Your Ref: OWPC19572
Our Ref: K/23/18/PL 12-06-2018
Please ask for:
Mrs A Gardner

Demolition & erection of 1 No. dwelling with swimming pool.
Little Deerswood Gorse Avenue East Preston

Thank you for your internet representation made on 9th August 2018 which has been recorded as '**an objection**' with the comments as follows:

North & East Elevations as proposed

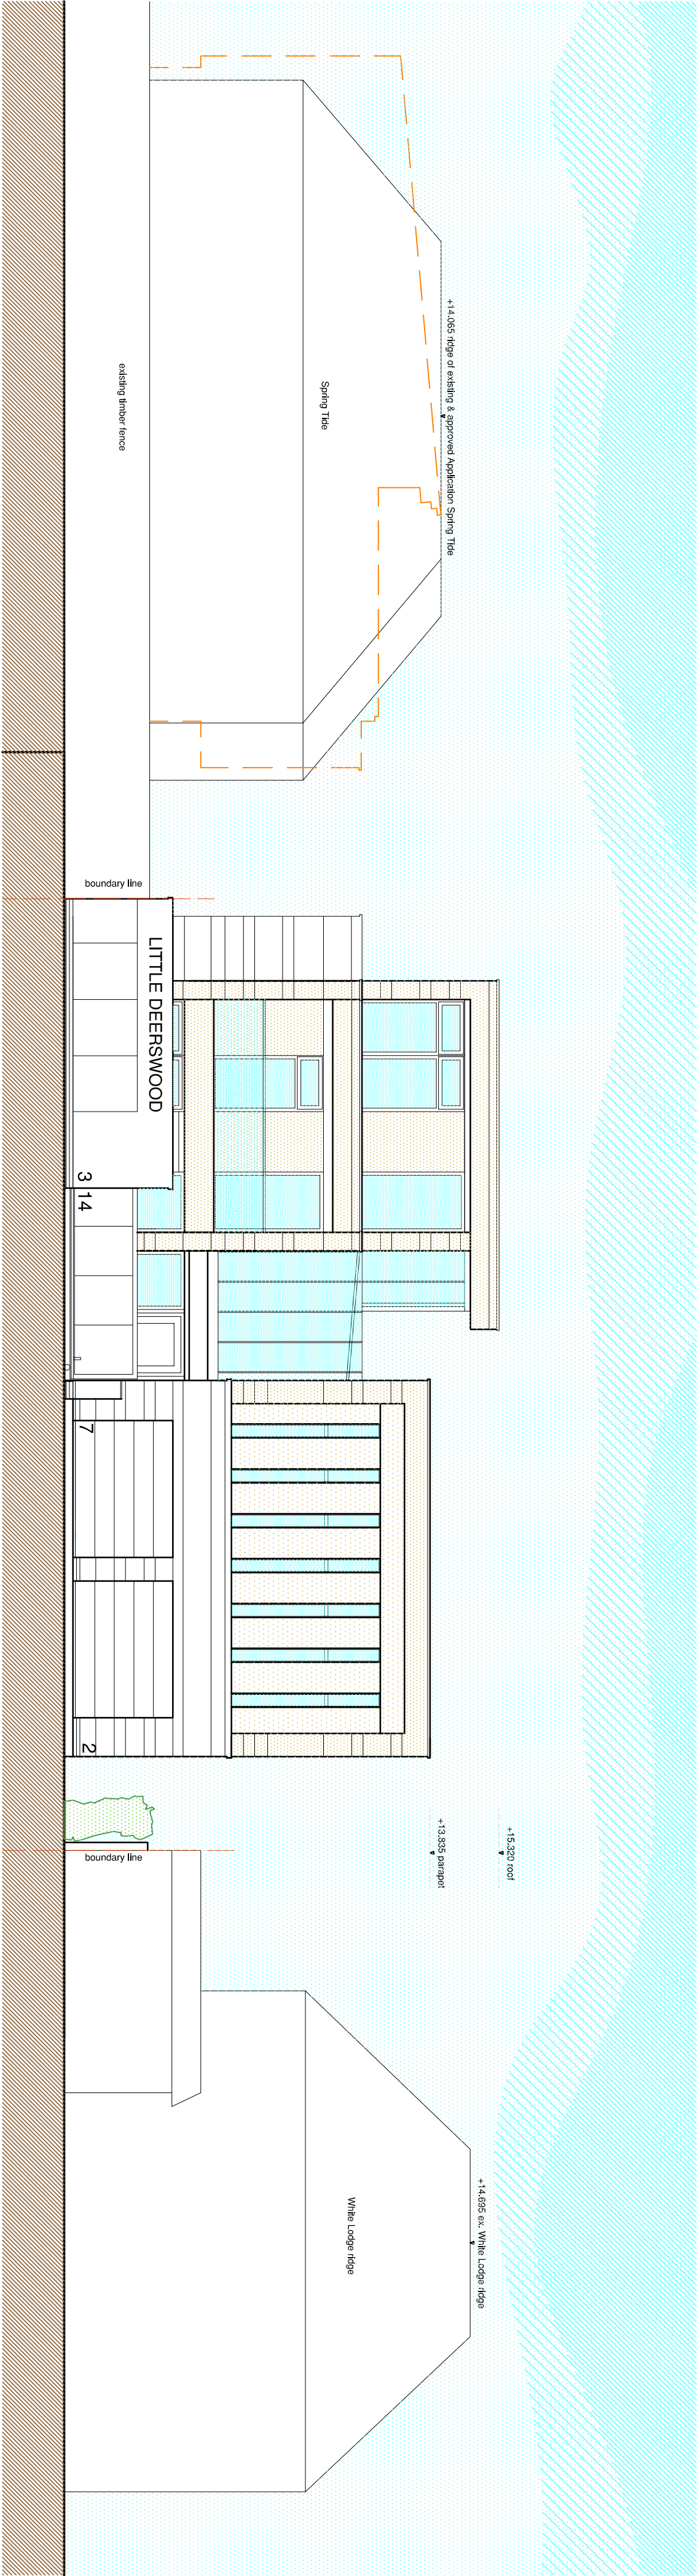
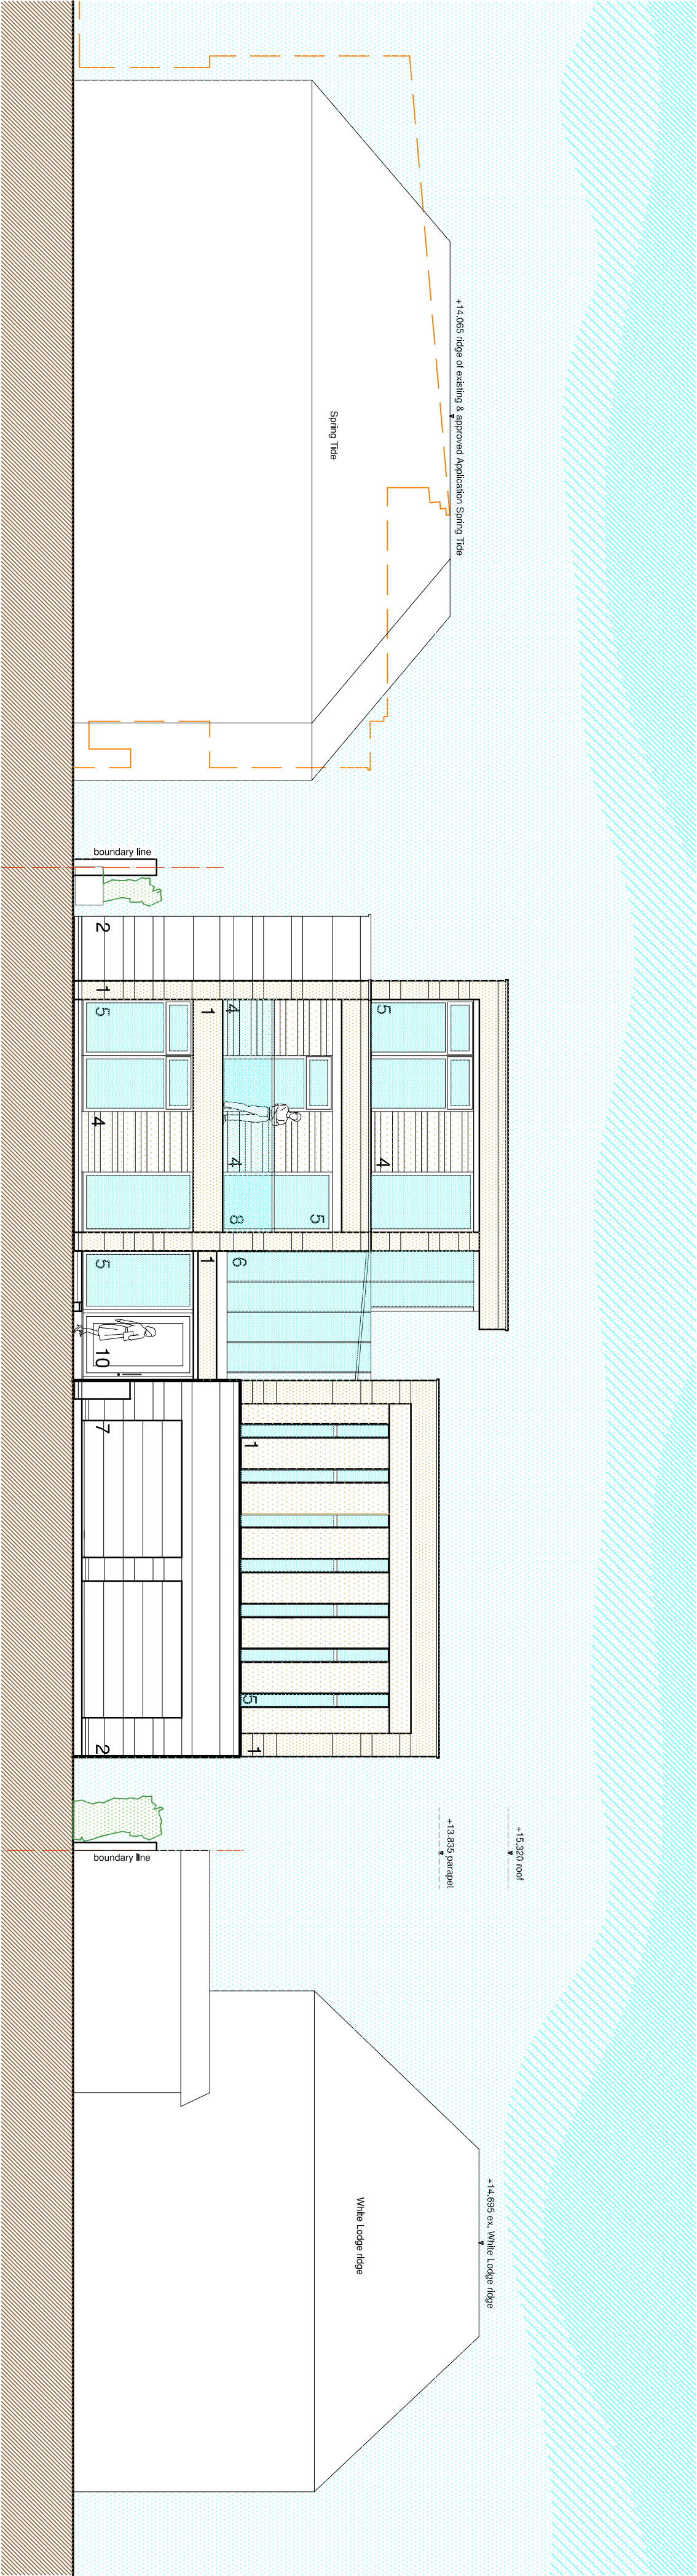
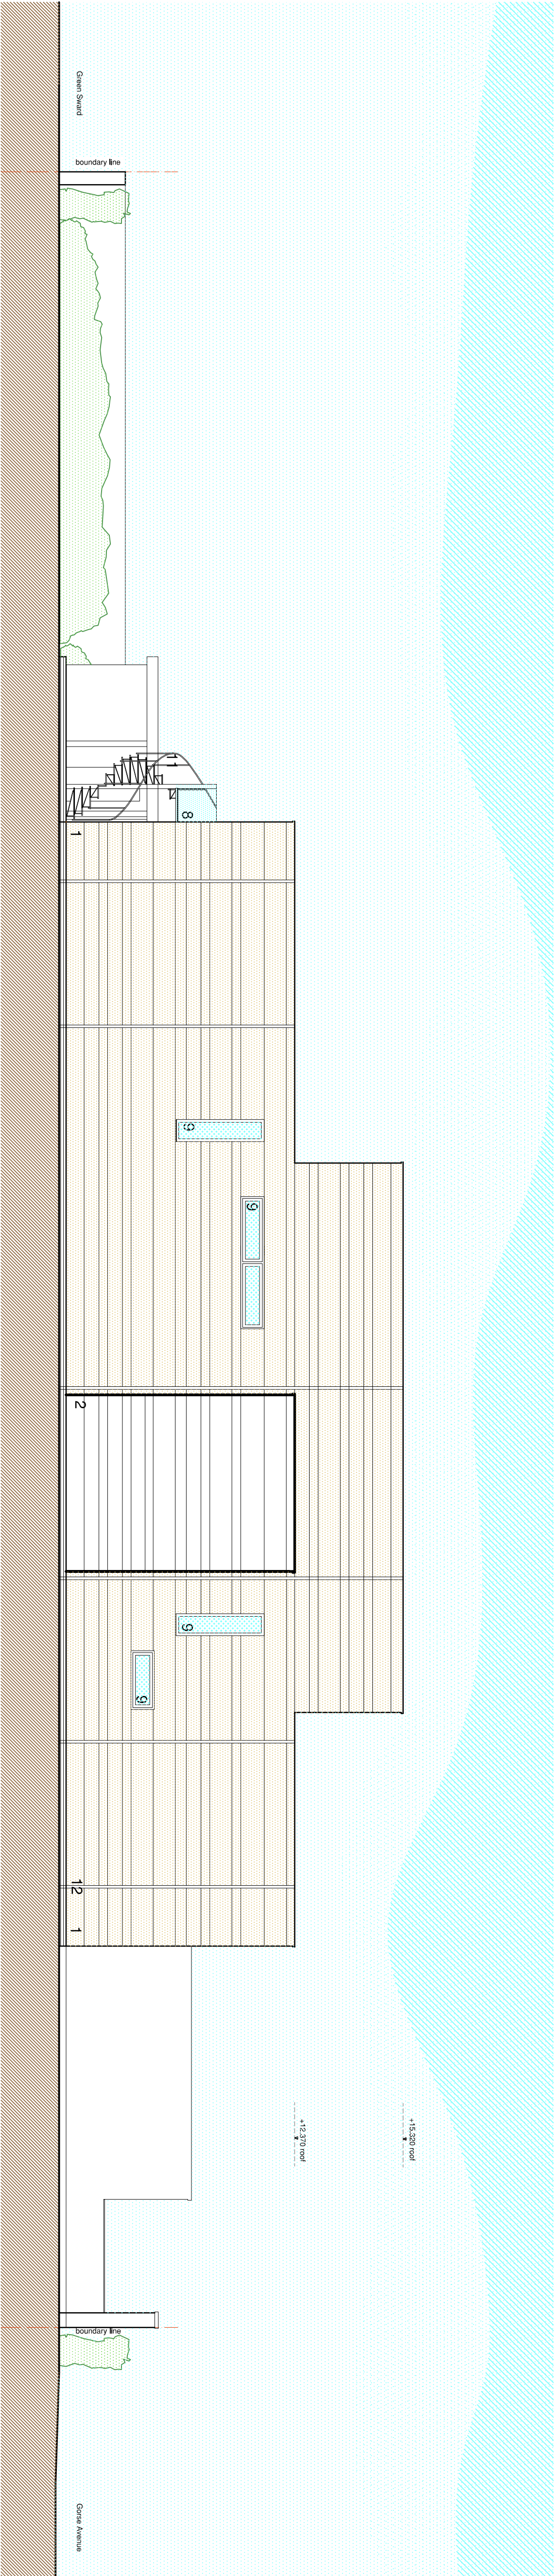
a) The second floor roof level is significantly higher than the ridge line of the properties to the east and west.

b) The proposed building has three stories. Although a few other three storey properties exist on the Estate these are dwellings where the third story is enveloped in the roof space and are not comparable with the planning application as they still effectively appear to be two storeys. The proposal would therefore be uniquely different to all other properties on the estate.

Site Plan as proposed

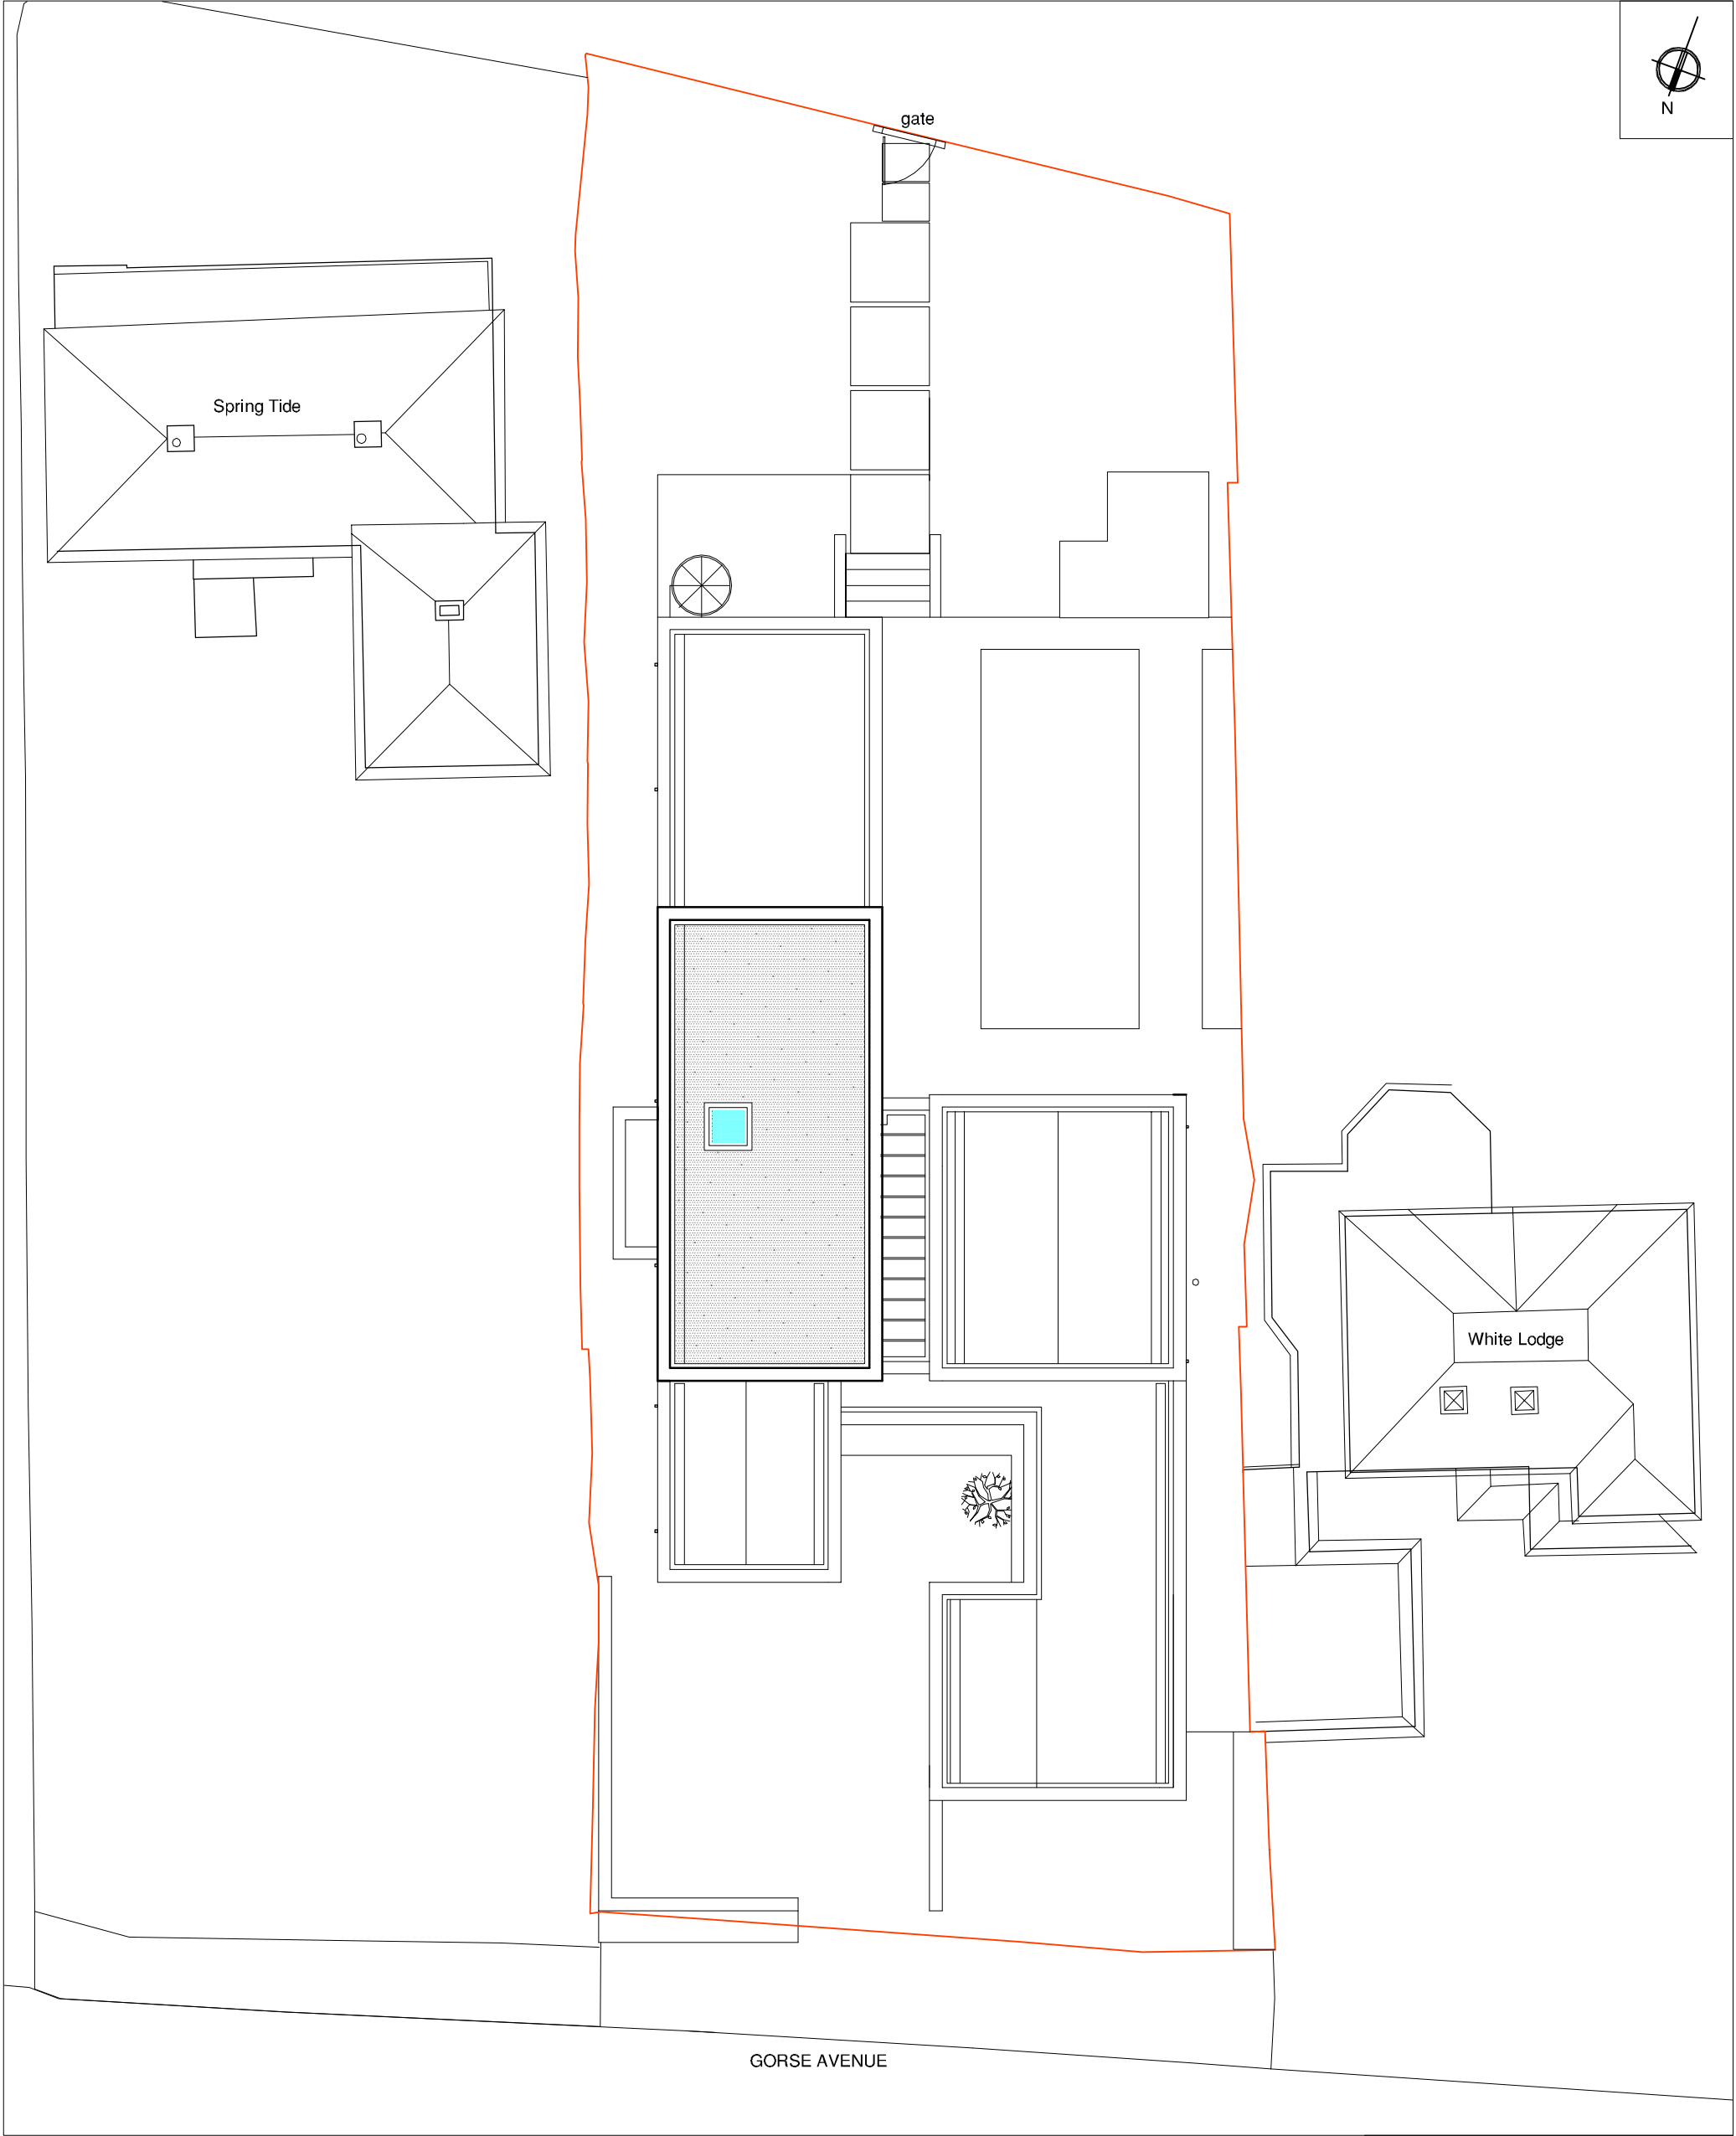
c) View: As the proposed building is significantly south of the existing building it will be of detriment to views afforded to the properties to the west thereby having an adverse effect on the residential amenity.

2. There is an over development of the site due to the increased building footprint and by its position south of the existing building line causing a loss of garden land and reduction in the open aspect of the neighbourhood.

1:100 West elevation as proposed

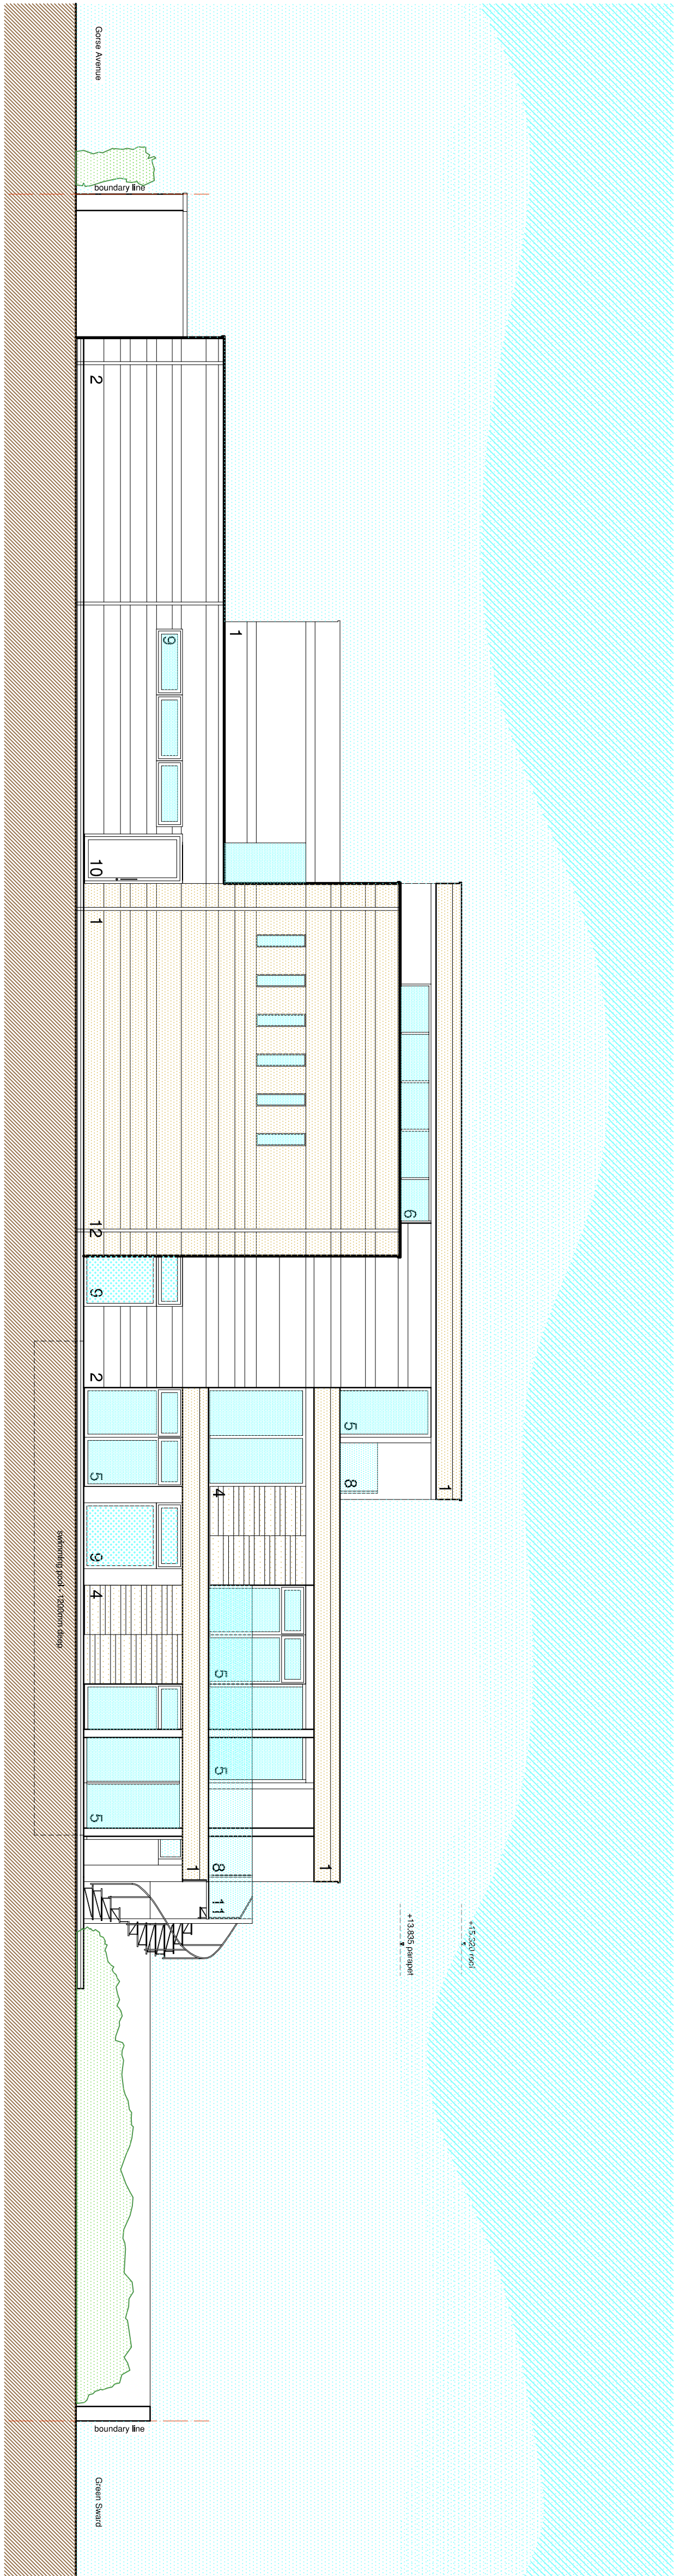
a) Overlooking: As the proposed building is significantly south of the existing building and has west facing windows it will overlook the properties and gardens to the west. Also the first & second floor balconies will overlook the properties to the west.

b) Privacy: The windows and balconies facing west will cause a loss of privacy.
